Application No: 20/01099/DISC-2

Proposal: Discharge of condition 2 (phasing plan) of 14/01932/OUT

Location: OS Parcel 7400 Adjoining And South Of, Salt Way, Banbury

Transport Development Control

Phasing Plan Condition 2 - Earthworks Plan

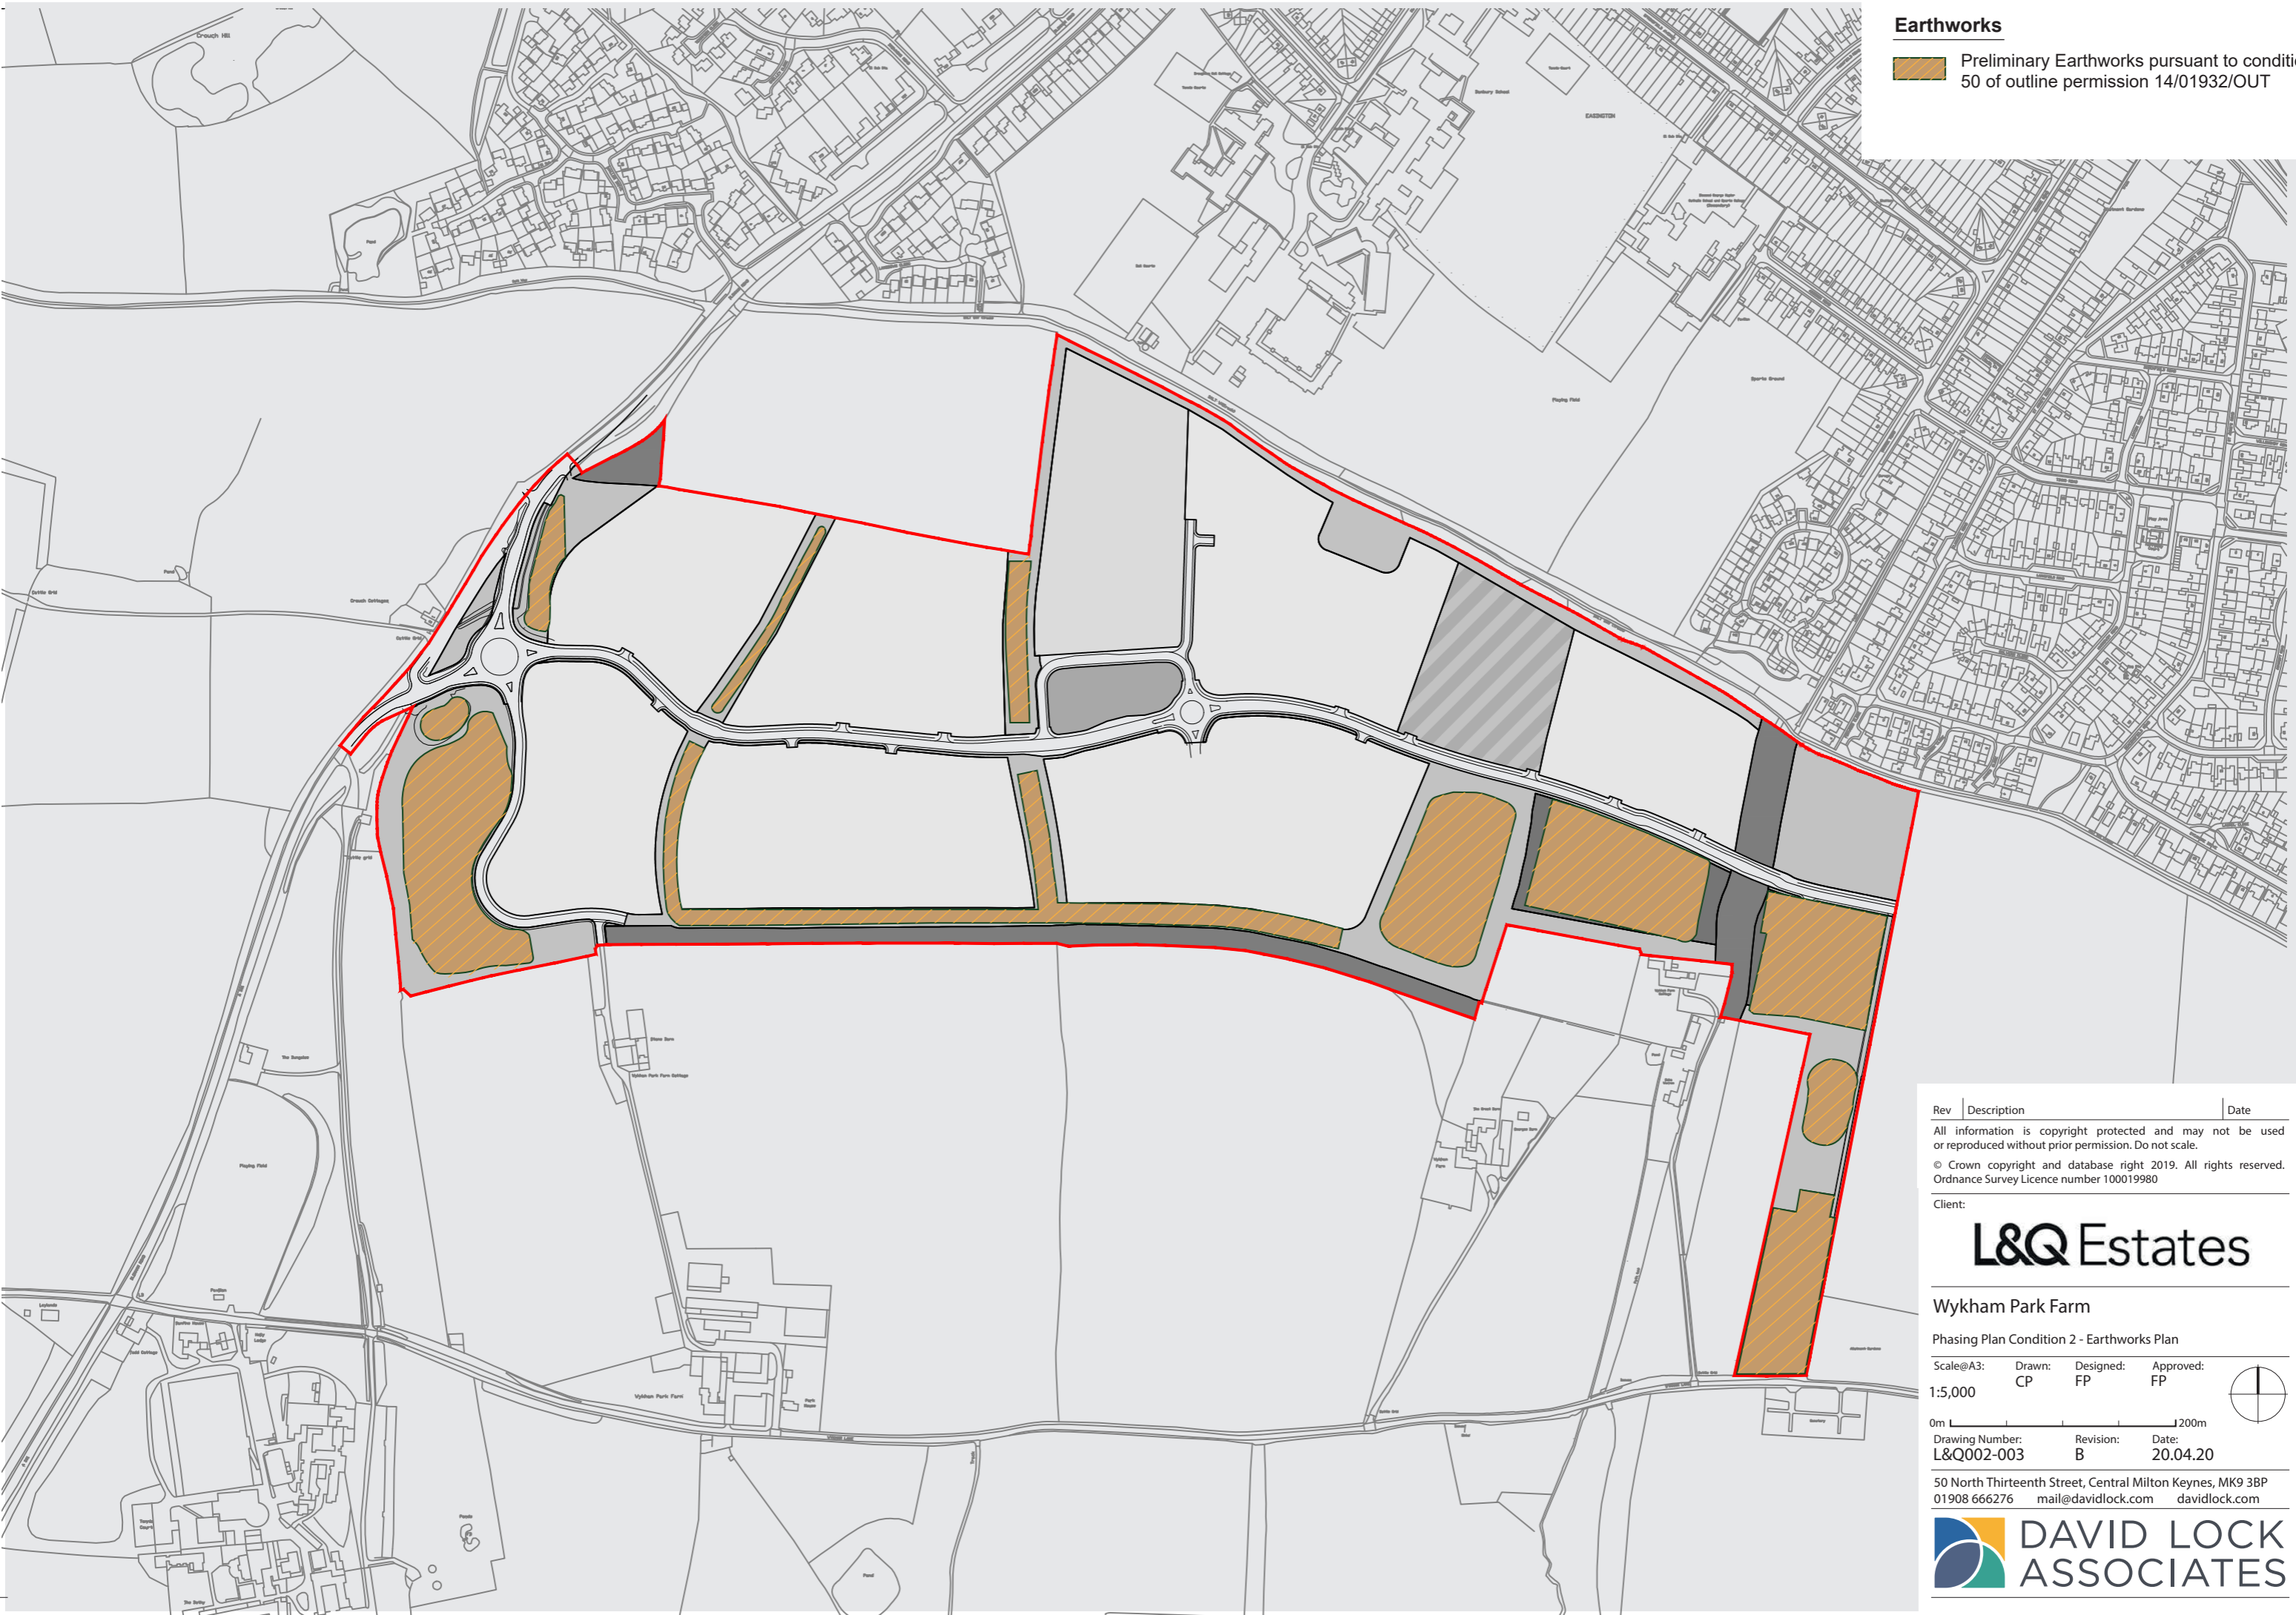
- Whilst it is specified in the S106 agreement, the phasing plan does not state the trigger for the primary street loop at the local centre.
- The trigger for the bridleway to be complete is 600 units. However, the section alongside parcels C and D and the primary school is a very important link up to Salt Way and will provide access to the primary school when it opens and has to take in pupils from outside the estate. The trigger for this section should be earlier. I suggest it should be provided prior to first occupation on parcels C or D and no later than the opening of the local centre.

- Whilst there is a trigger for the provision of the community centre, there is nothing in the phasing plan about the opening of the car park at the local centre. This is critical for the operation of the primary school. I suggest it should be provided at the same time as the primary street loop past the school.

- There is no time commitment to complete the dotted line 'indicative leisure routes' These are a key part of pedestrian connectivity for residential parcels and their completion should be tied into the phasing of those parcels. I note that the drainage swales at these locations are due to be complete prior to the first occupation of any dwelling on parcels A-F.

- Emergency access – legend should state that it must connect to the spine road by 400 dwellings.

- Bus stops – I understand that Stagecoach has queried the positions of bus stops and is seeking a meeting to discuss them. I'd suggest that it should be indicated that locations are provisional only in this phasing plan.
- Access points to residential parcels – these are not fixed and will be agreed as part of the reserved matters application for the spine road. These should be marked as indicative only.
